ASSESSMENT REPORT

1 Lawson Square, Redfern SSD 5249 MOD 3

Figure 7: Approved northern façade of towers
(Source: MOD 2)

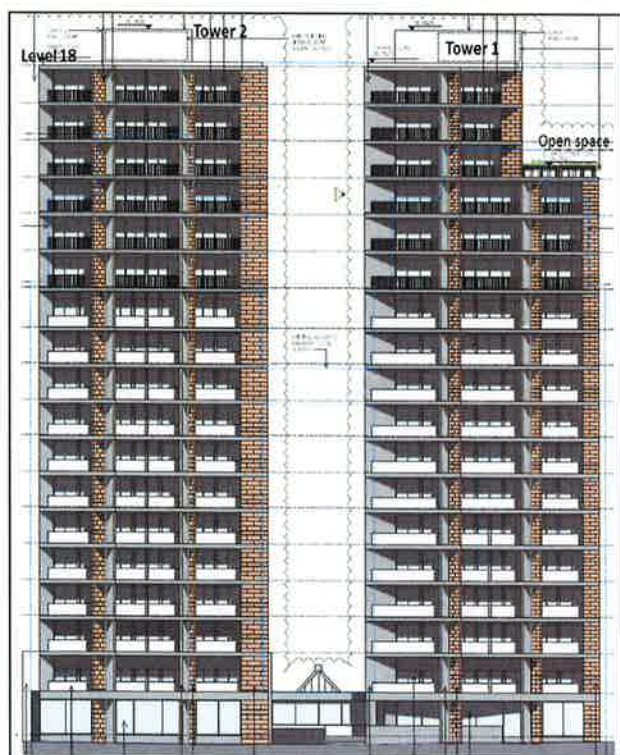
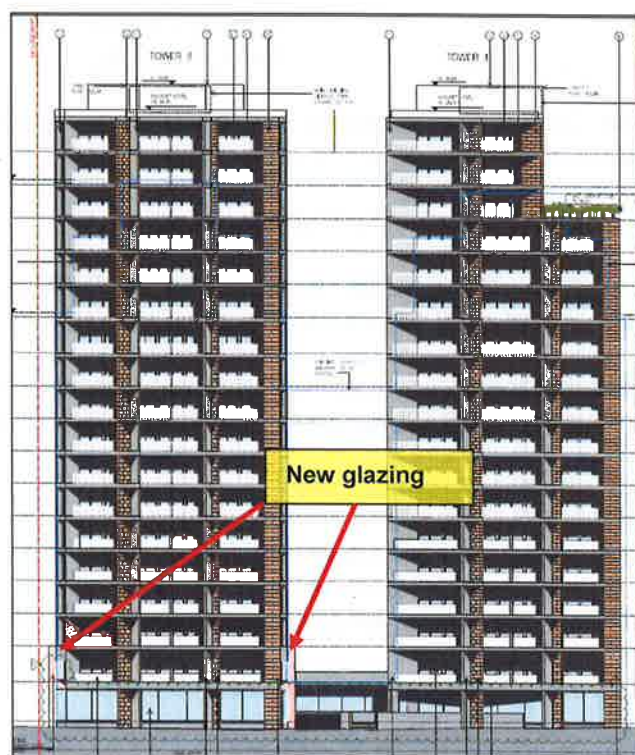
The changes to the north façade are limited to the ground and first floor commercial levels of Tower 1 which would replace some glass reinforced concrete with glazing (**Figures 7 and 8**). The amendments would not change the strong vertical expression of the tower's northern facade nor its material proportions of marble and off-form concrete. The changes to the northern façade of Tower 1 are therefore supported.

Figure 10: Proposed eastern and western elevation of Tower 1 (Source: Plans MOD 3)

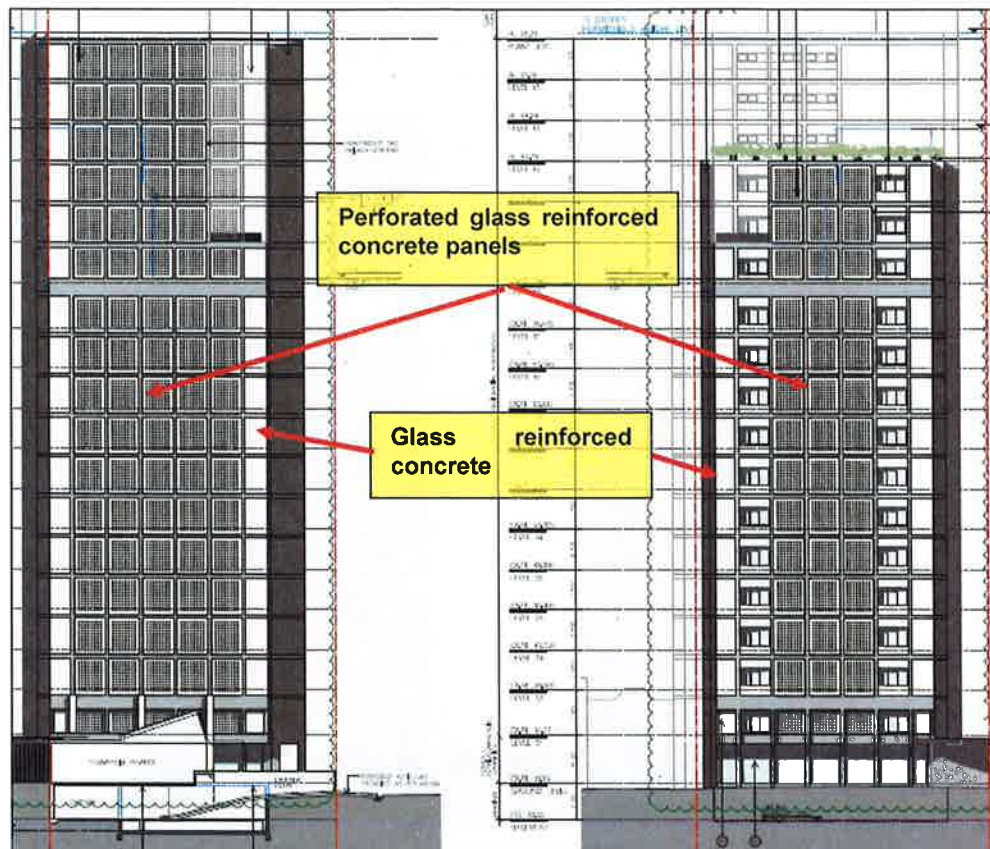
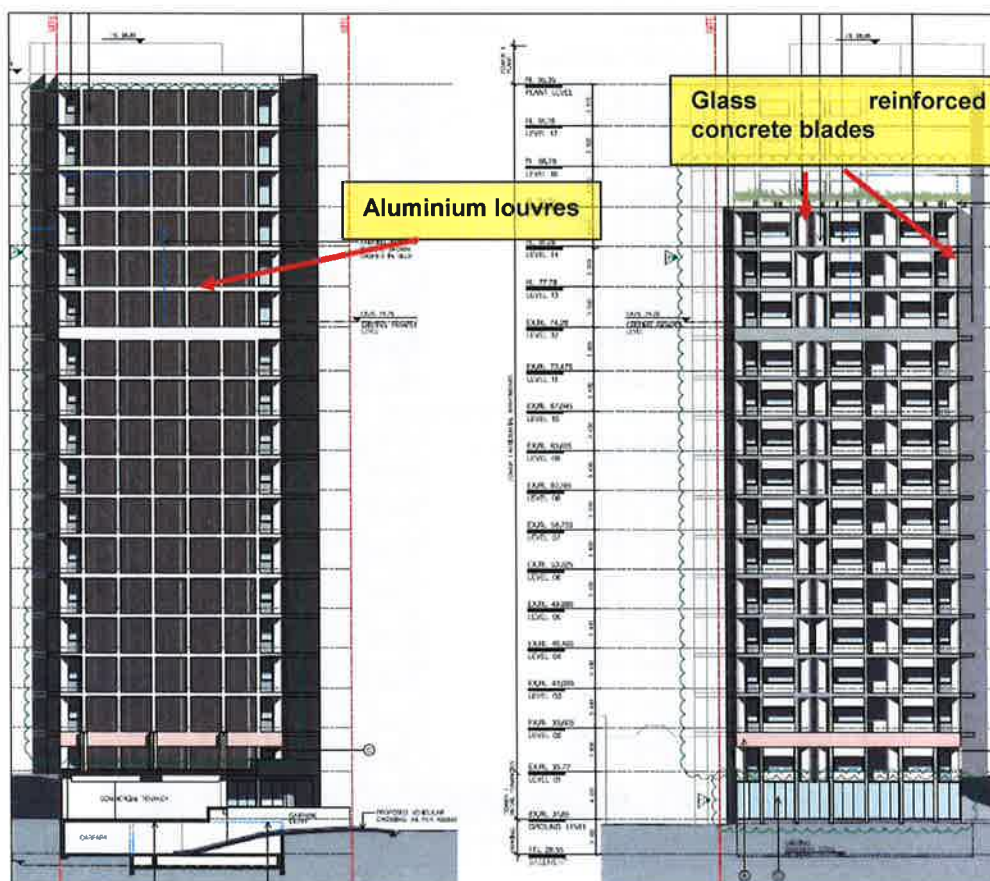
The approved perforated glass reinforced concrete screens are proposed to be replaced with glass reinforced concrete blades and aluminium louvres on the eastern and western facades of both of the towers (**Figures 9 and 10**). The changes would open up the facades of the towers and improve the internal amenity of the apartments by providing additional sunlight and views. The Department considers the changes to the towers would provide greater articulation and improved architectural expression and are therefore supported.

Figure 12: Proposed southern elevation of Towers 1 and 2
(Source: MOD 2)

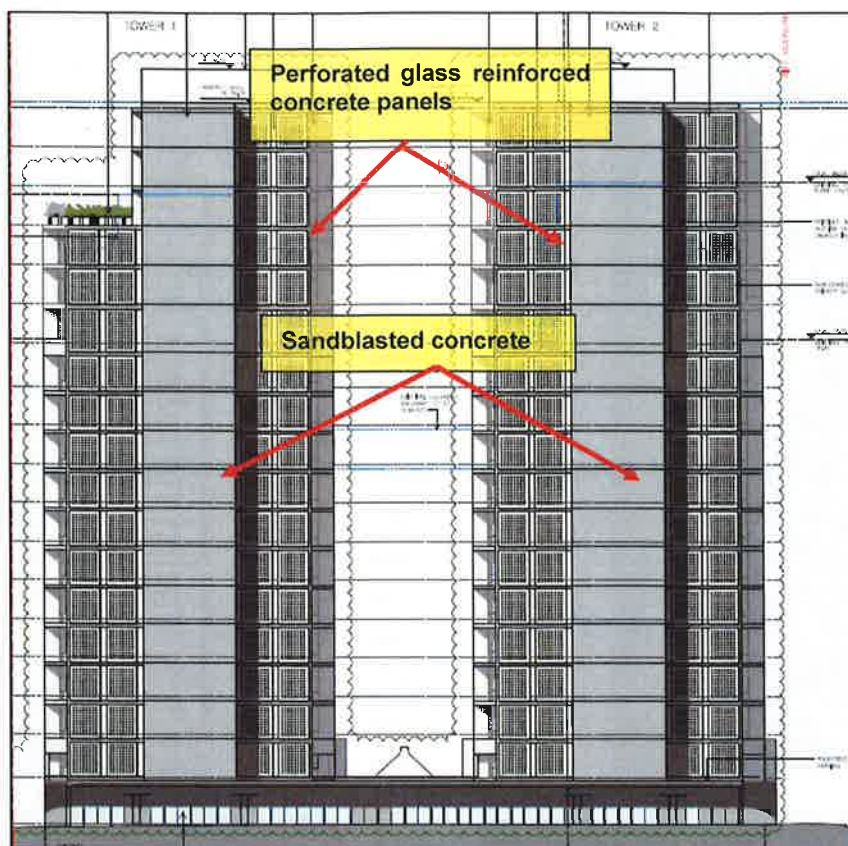
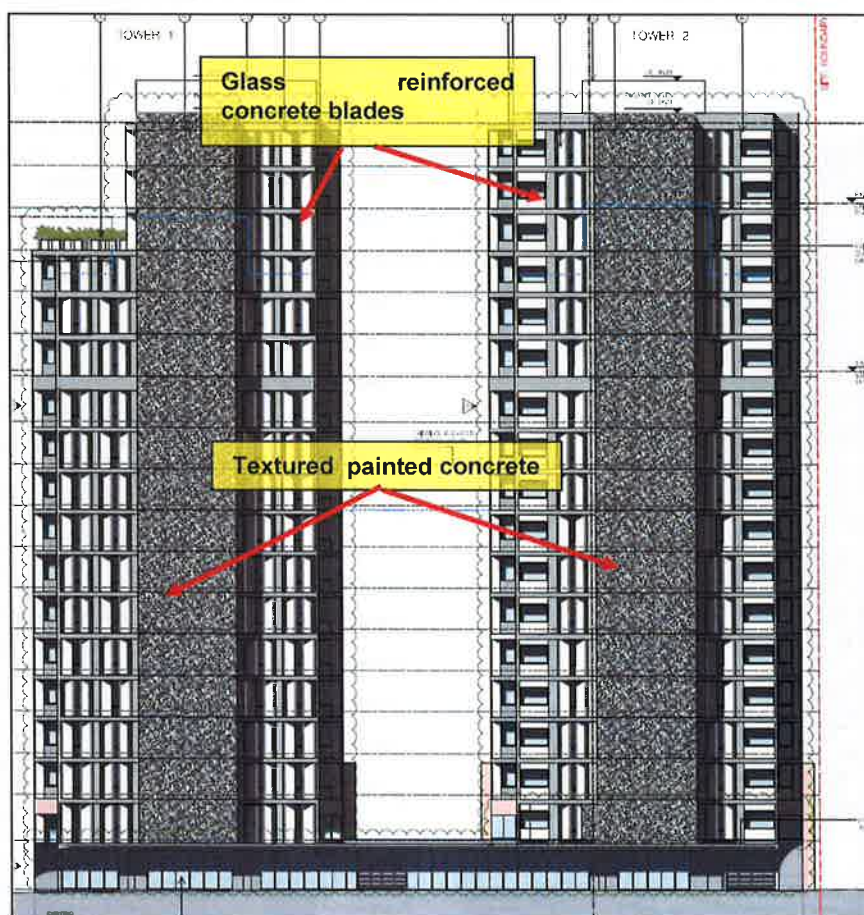
On the southern façade of the towers, the perforated glass reinforced concrete panels and sandblasted concrete would be replaced by glass reinforced concrete blades, glazing and textured painted concrete respectively (**Figures 11 and 12**). The Department considers the removal of the glass reinforced concrete panels would improve the articulation of the southern facades of the towers and provide greater vertical expression. This would act to reduce the façade's massing and improve the towers' proportions and visual appearance. The replacement of the sandblasted concrete with a textured maintained concrete would complement the overall palette of materials and maintain the overall aesthetic quality of the towers.

Figure 13: View lines between Tower 1 and 157 Redfern Street (Source: EIS for MOD 3)

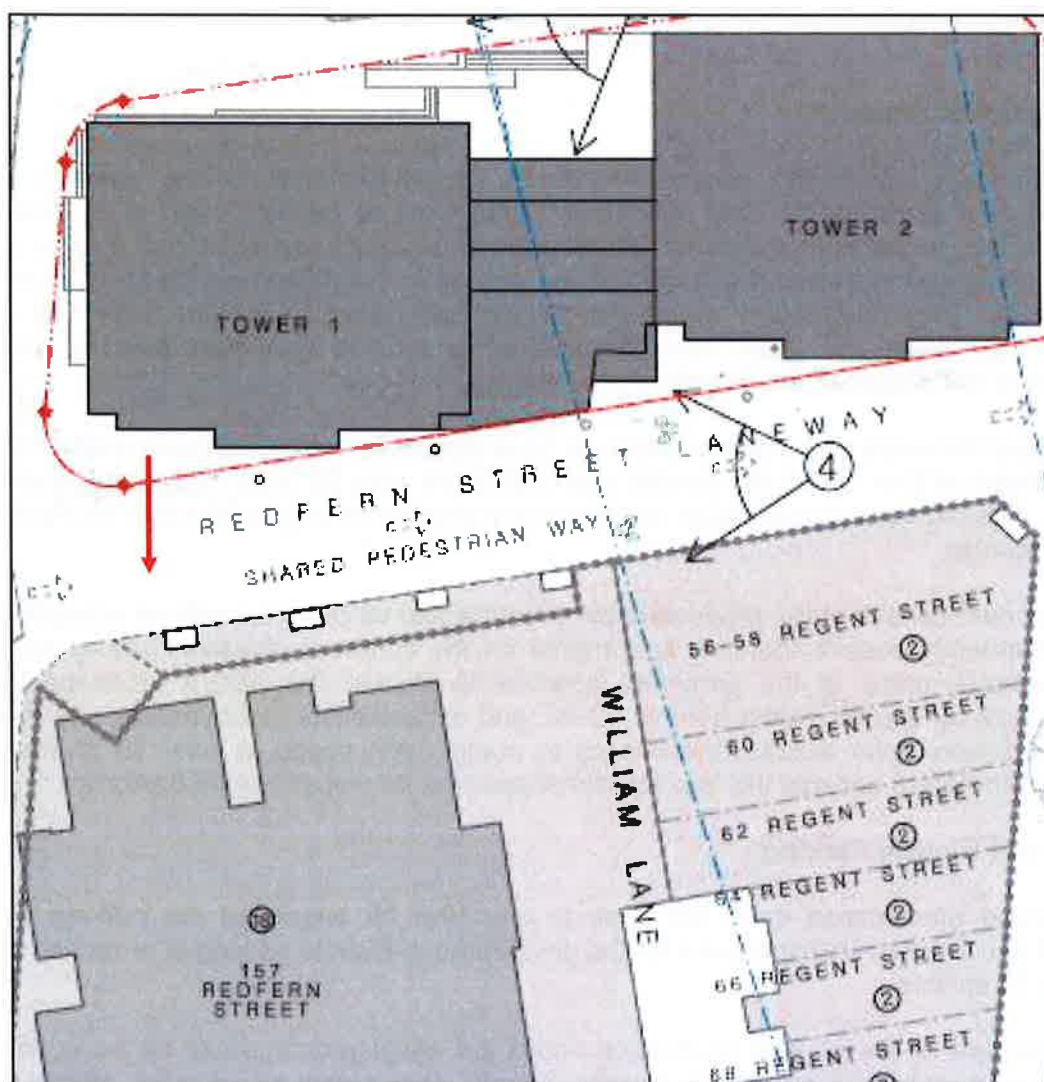
The modification seeks to remove the perforated glass reinforced concrete panels which face the southern residential apartment building at 157 Redfern Street. A public submission was received regarding privacy impacts from the south-facing windows of the western tower (Tower 1) to the north-facing apartments of 157 Redfern Street. The public submission raised concerns about the apartments in Tower 1 having bedrooms, living rooms and kitchen windows located to the south which would increase the potential for overlooking between the southern façades of Tower 1 and 157 Redfern Street.

The view lines between Tower 1 and 157 Redfern Street are identified at **Figure 13** below.

- the rooms on the southern elevation are bedrooms, bathrooms and corridor/study areas, with kitchen, dining and living rooms orientated to the east or west to avoid overlooking residents to the south
- the bedrooms on the southern elevation have opaque glass reinforced concrete blades fixed to the windows to prevent overlooking, which are angled away from 157 Redfern Street
- the bathrooms on the southern elevation have opaque glass windows and panels which will prevent overlooking
- it is only the corridor/study areas which have a small window facing south and these windows are already approved under MOD 2.

The Department considers the use of glass reinforced concrete blades and aluminium louvres which are appropriately glazed and angled, ensure that a reasonable level of privacy would be maintained to the adjacent residents at 157 Redfern Street. Additionally, the changes proposed to the layout of apartments on the southern elevation would ensure that living areas are orientated away from the south to mitigate overlooking potential. The Department further notes the residents at Tower 1 and 157 Redfern Street are separated by approximately 17.1 m which also mitigates overlooking potential.
